# SITE DEVELOPMENT PLAN FOR SECURITY WATER DISTRICT WATER TREATMENT PLANT BUILDING ADDITION

AUGUST 2024

**SWD PROPERTY SITE PLAN**  
WATER TREATMENT PLANT BUILDING ADDITION  
SECURITY WATER DISTRICT

**BUILDING SITE PLAN**  
WATER TREATMENT PLANT BUILDING ADDITION  
SECURITY WATER DISTRICT

SHEET
6
7

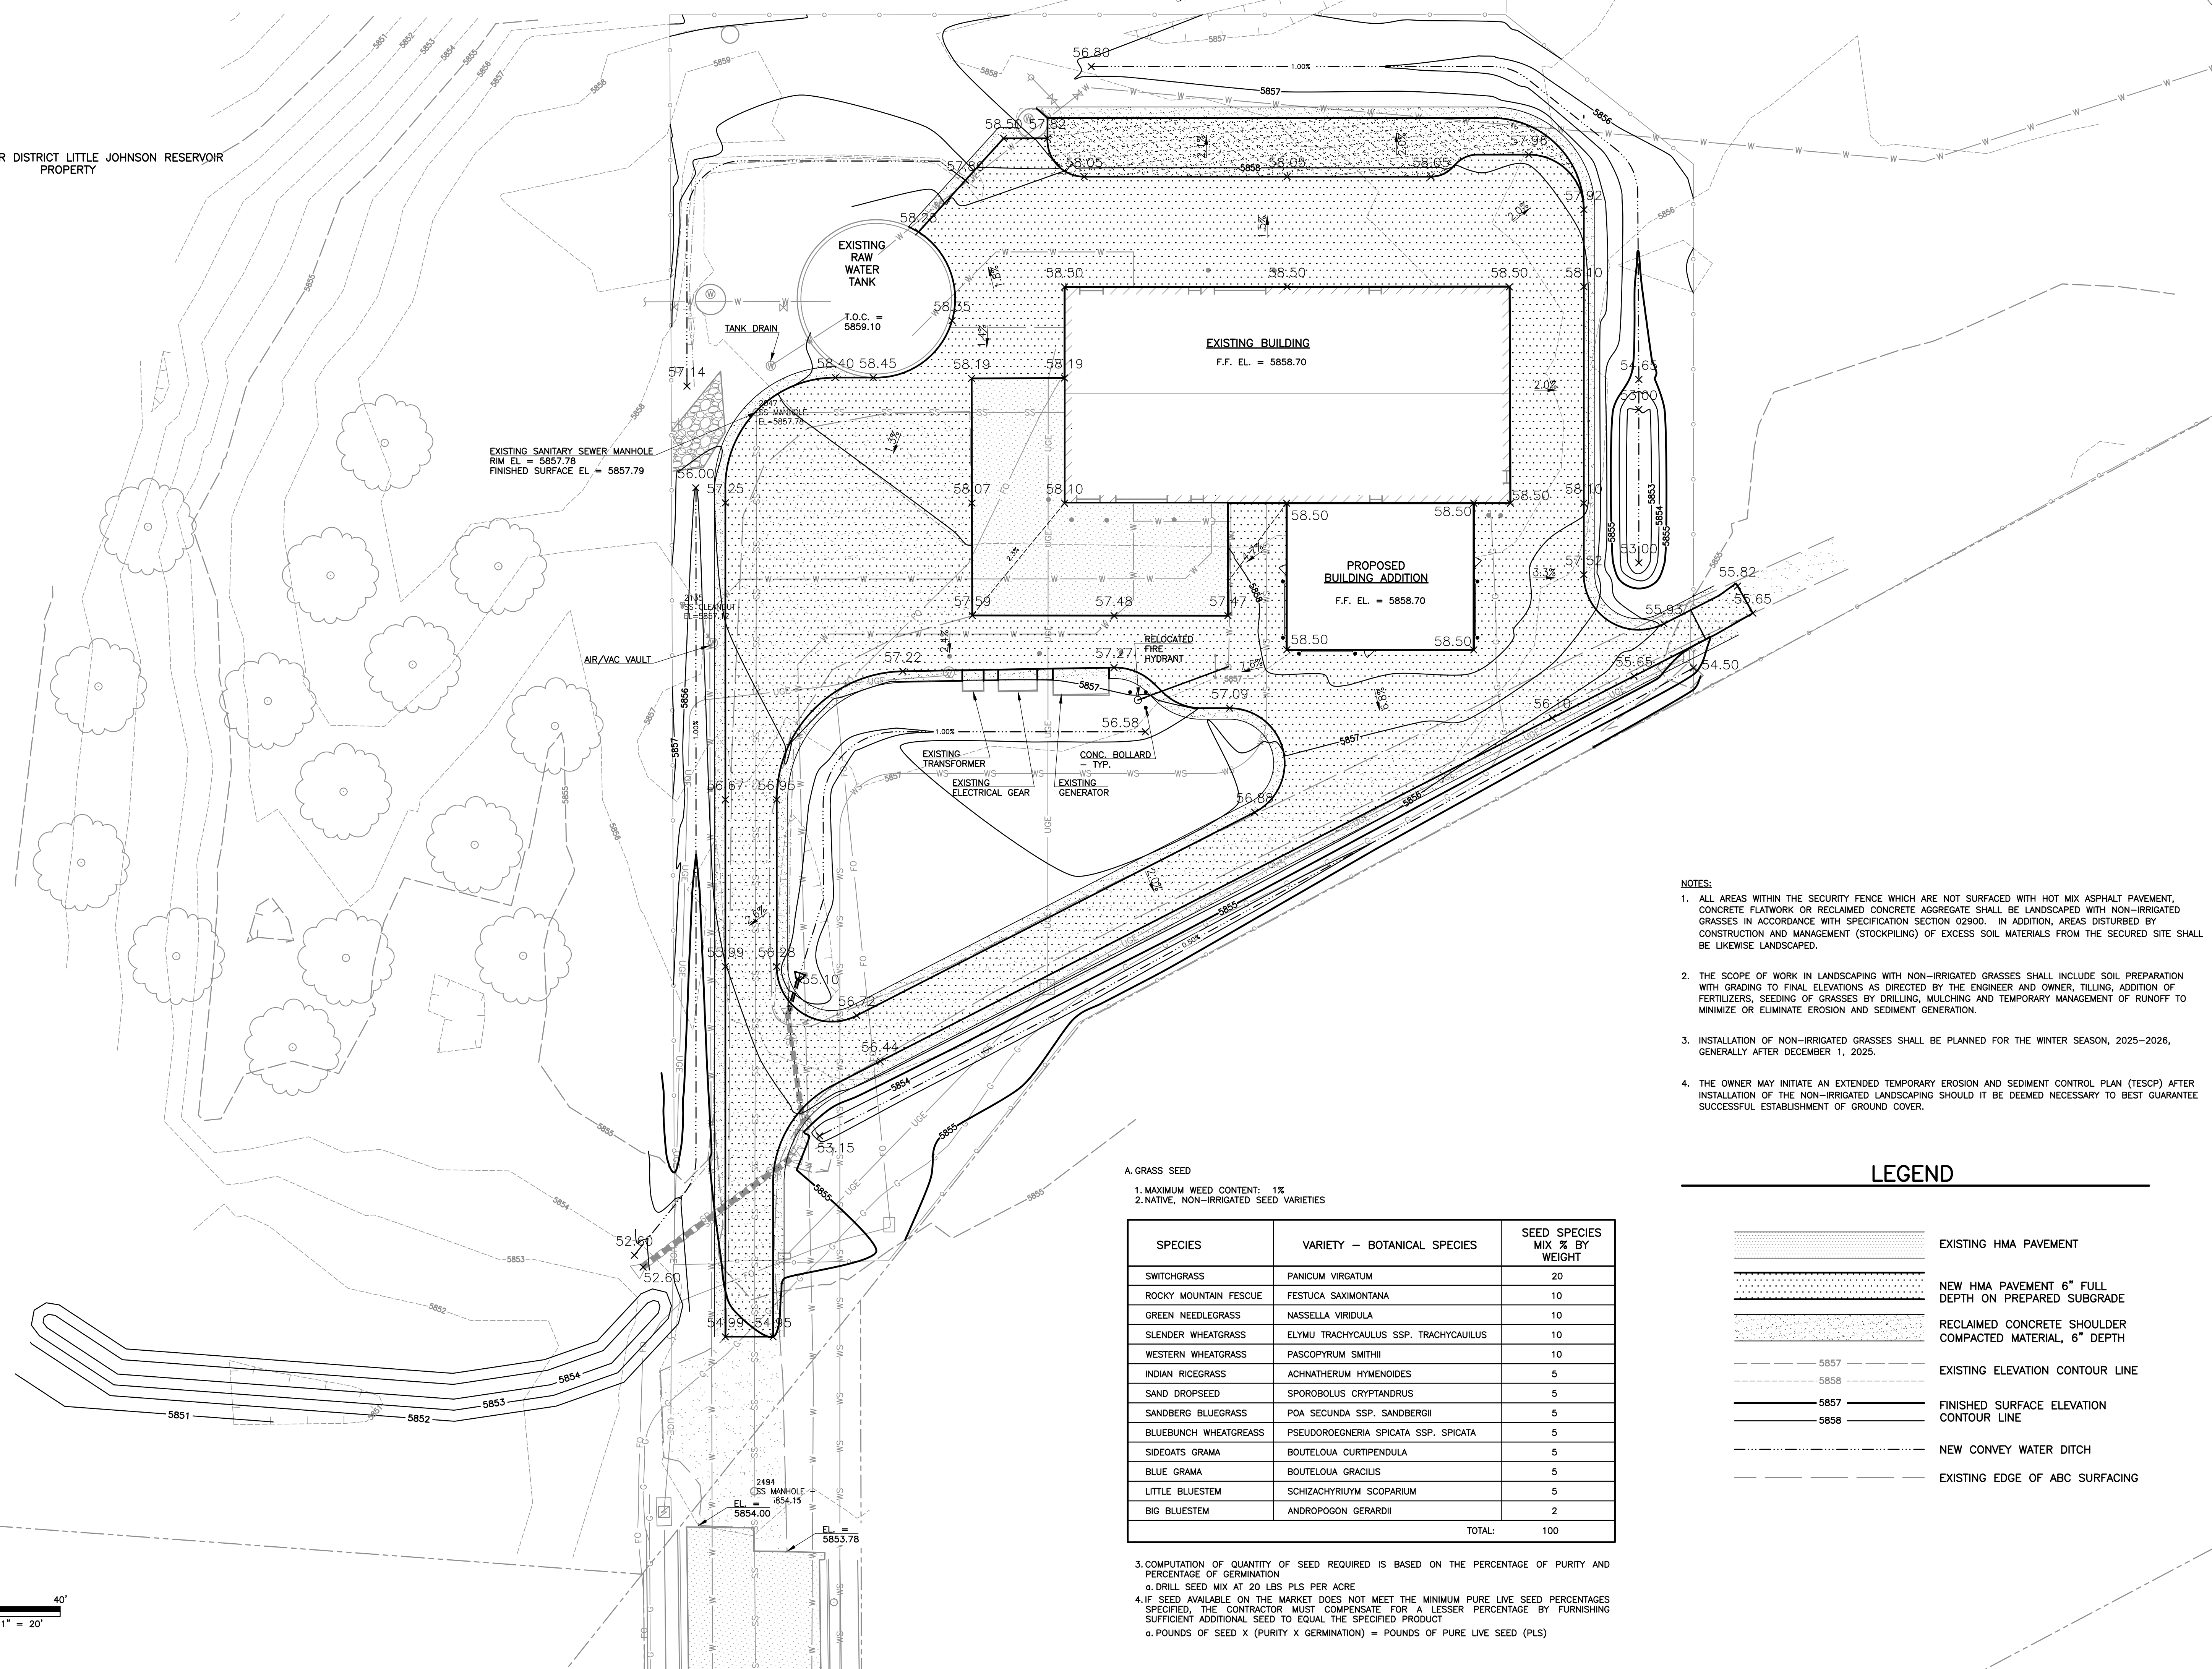
Provide this sheet (or just the area in the orange box) in the GEC plan, where the design is approved by the engineering department

Provide callout for end cap and orifice hole of outlet pipe
